From: Shaun Moore [REDACTED]
Sent: 25 March 2019 11:18
To: Charlotte Easton
Subject: RE: 34 The Green, Pagham - P/15/19/HH

I write to you regarding application P/15/19/HH – 34 The Green, Pagham.

First Floor Plan

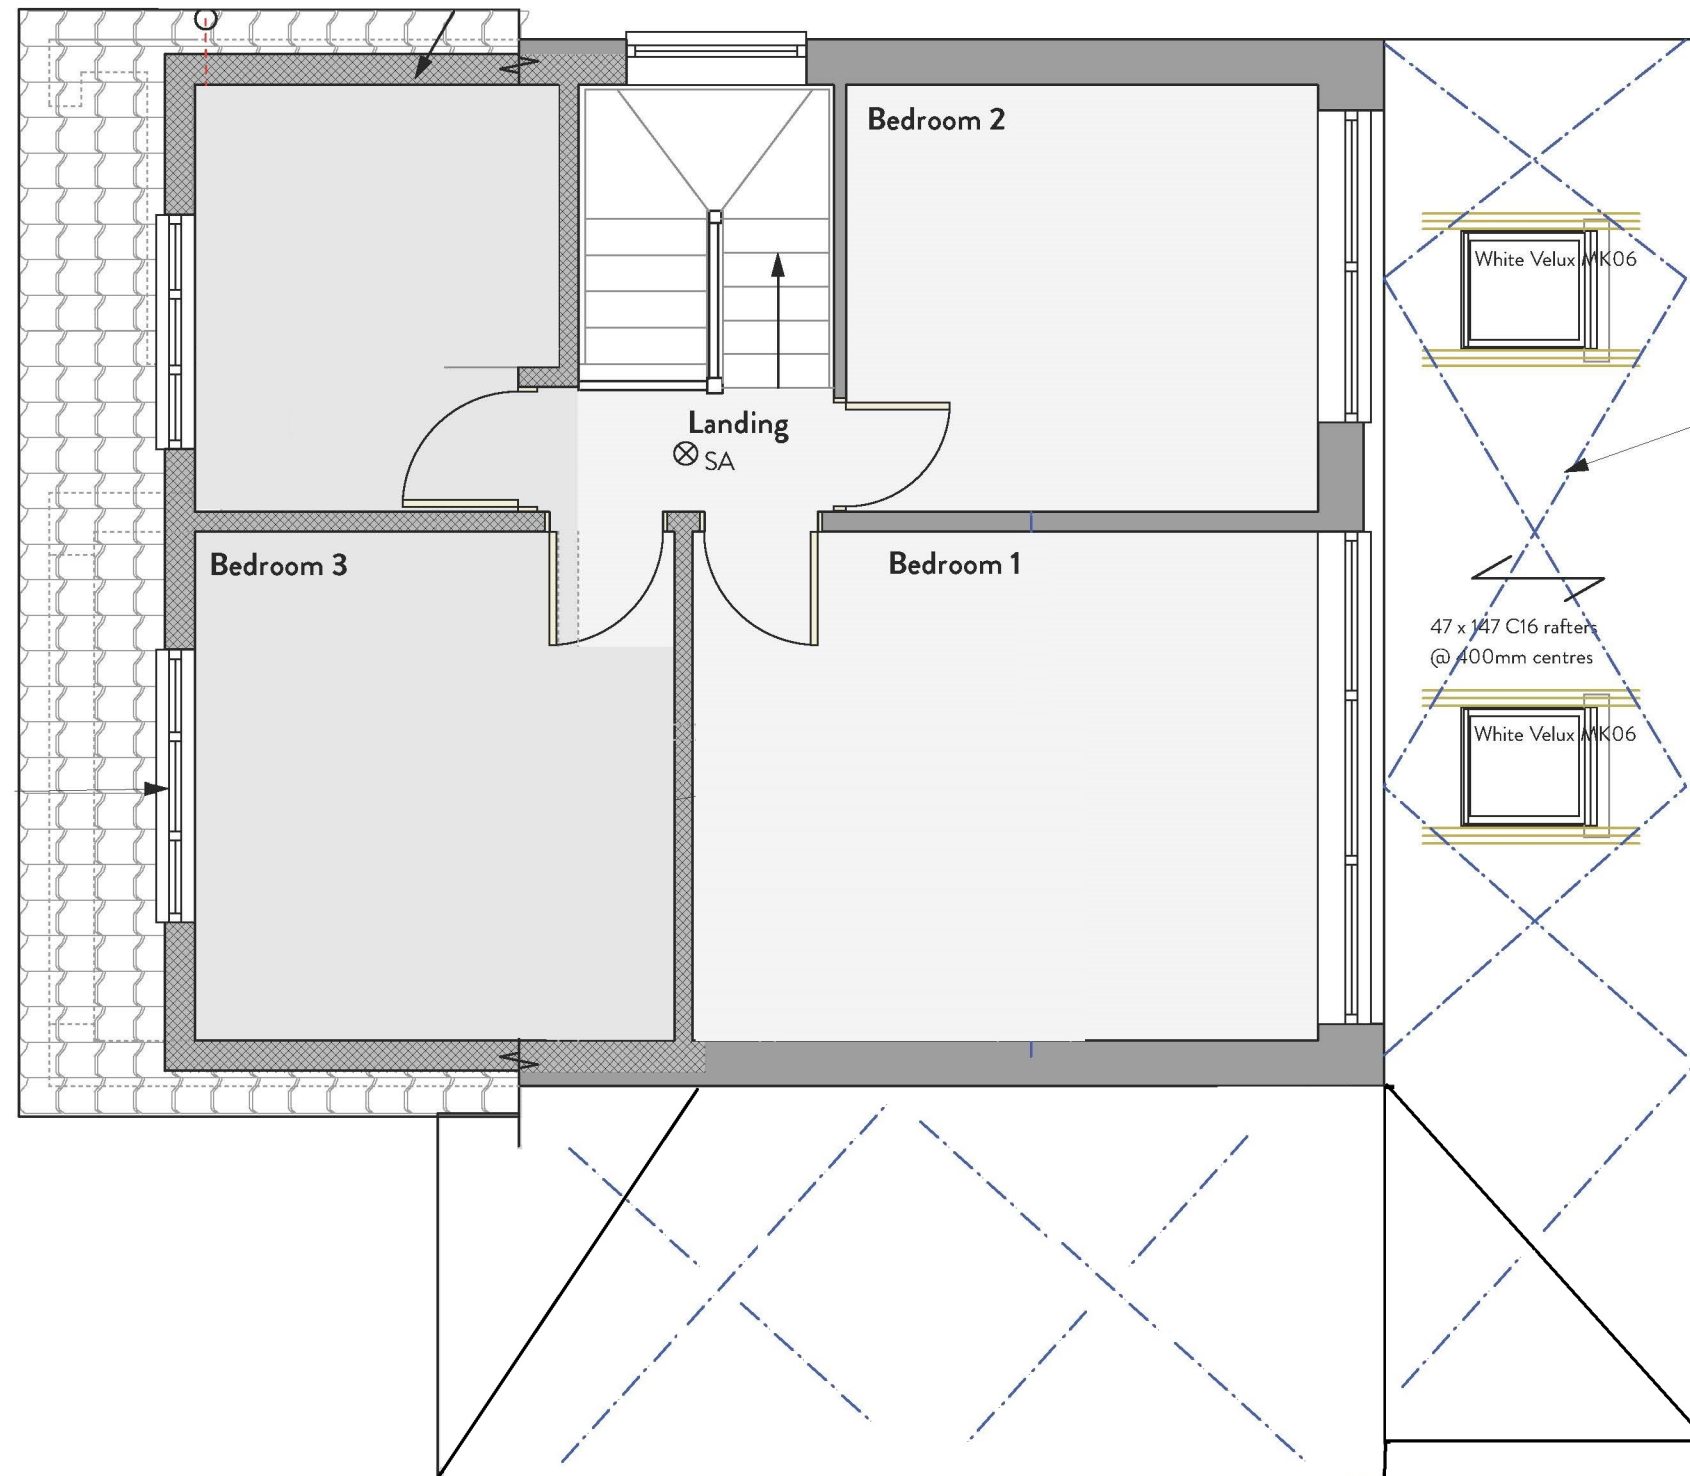
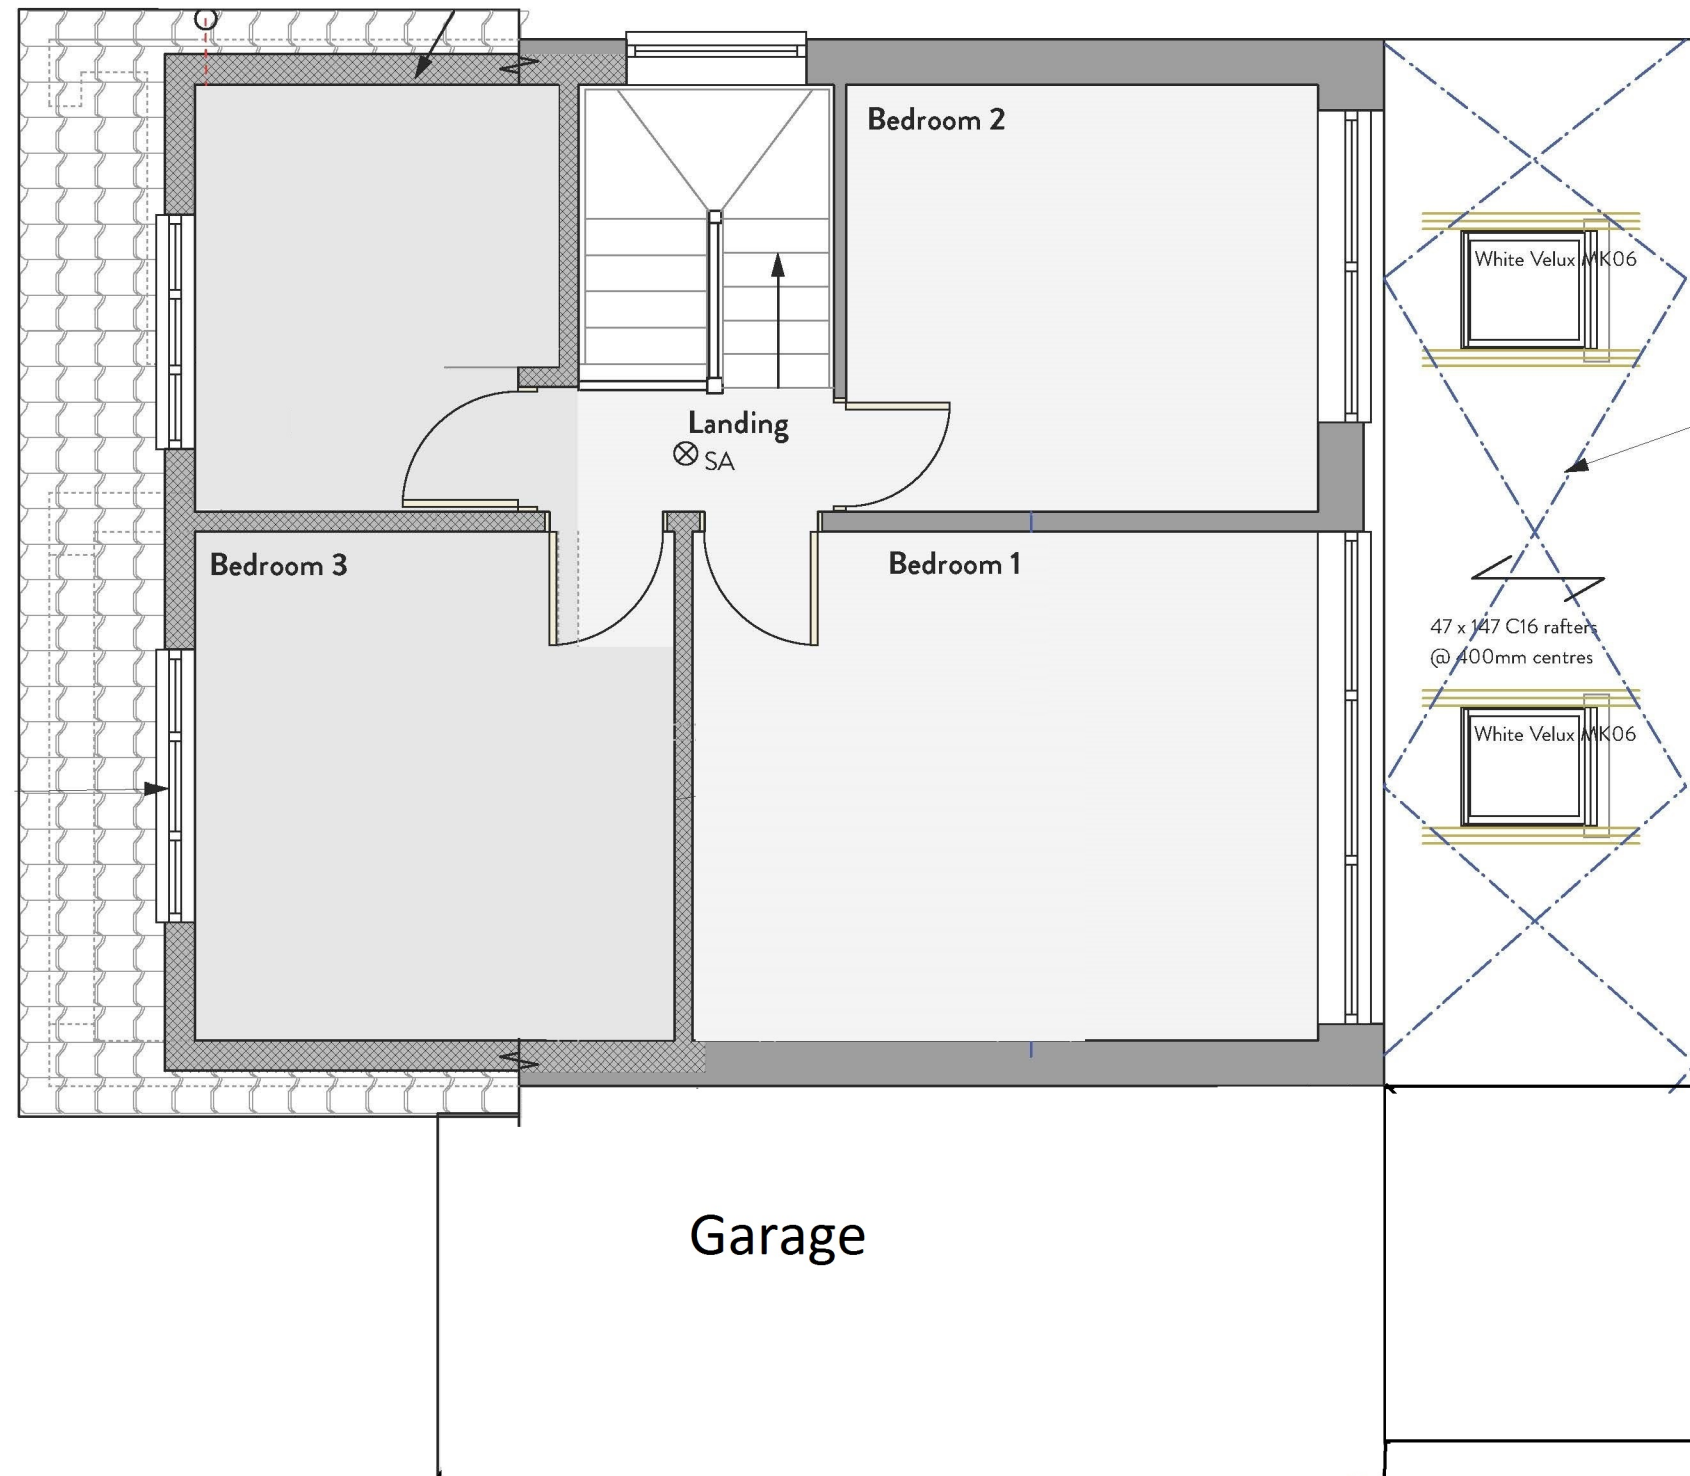
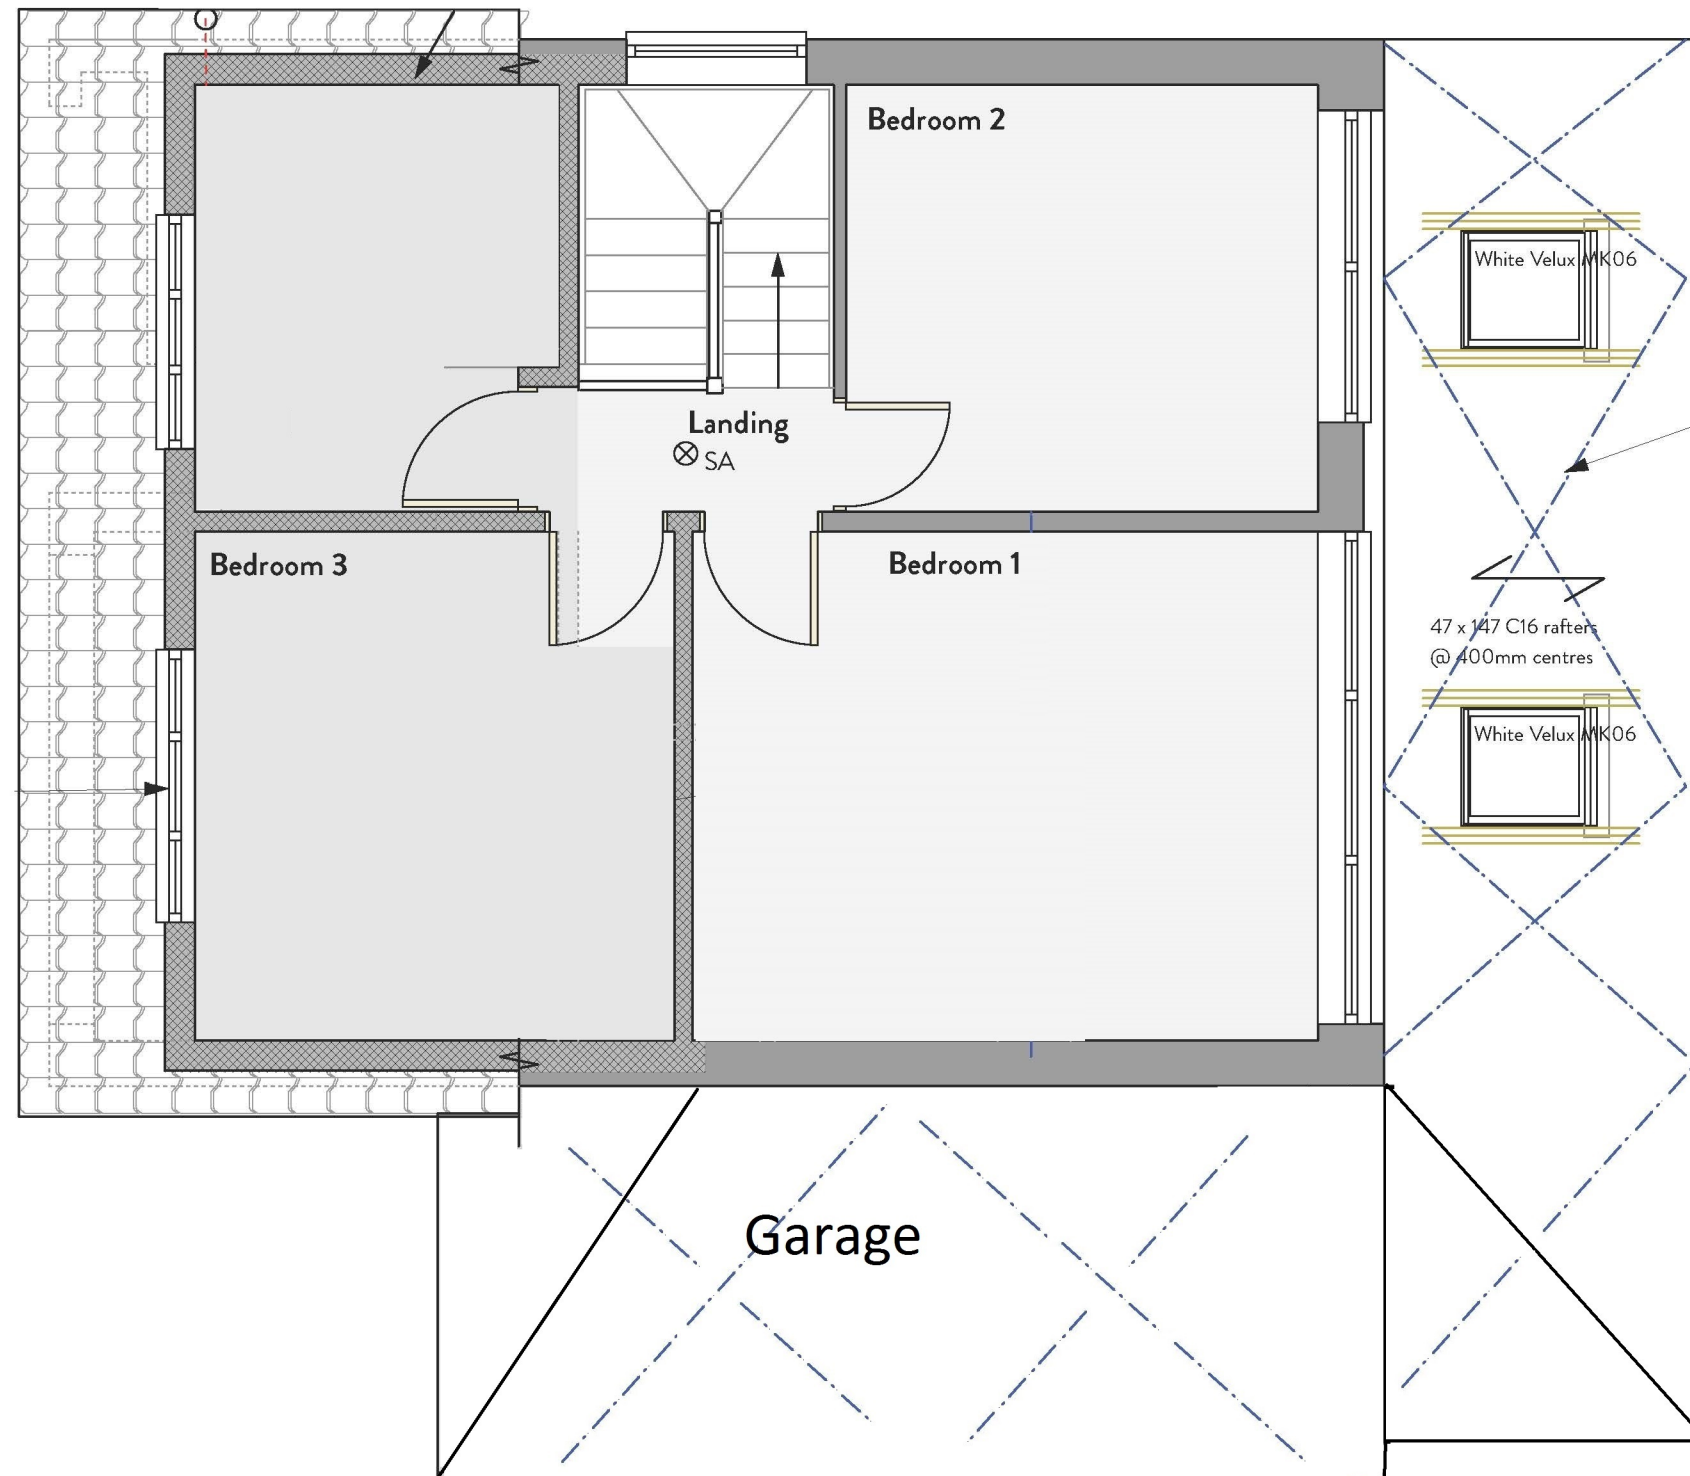
Ideally, we would have one first floor plan labelled existing floor plan and then one with the proposed roof alteration indicated labelled as proposed first floor plan. Given the proposal is for a roof alteration the plans will not look overly different.

- We do not appear to have an existing floor plan of the roof. Do I just need to add the word "garage" to the "First Floor Plan"
- The proposed Velux window need to be indicated on the Block Plan. The Velux are not part of this application?. I have attached a photo and outlined in red the garage roof this application related to, the rest was approved last year as part of a different application PH/14/18/HH. Also the Velux would be so small I cannot see how I could add them to the "Site & Location Plans" document uploaded on the 18th Feb under Location and Block Plans on the website,. Any guidance would be greatly appreciated.

Thank you and that makes perfect sense, I will amend over the next few days and get back to you. The first floor plan won't be any different but happy to label them differently.
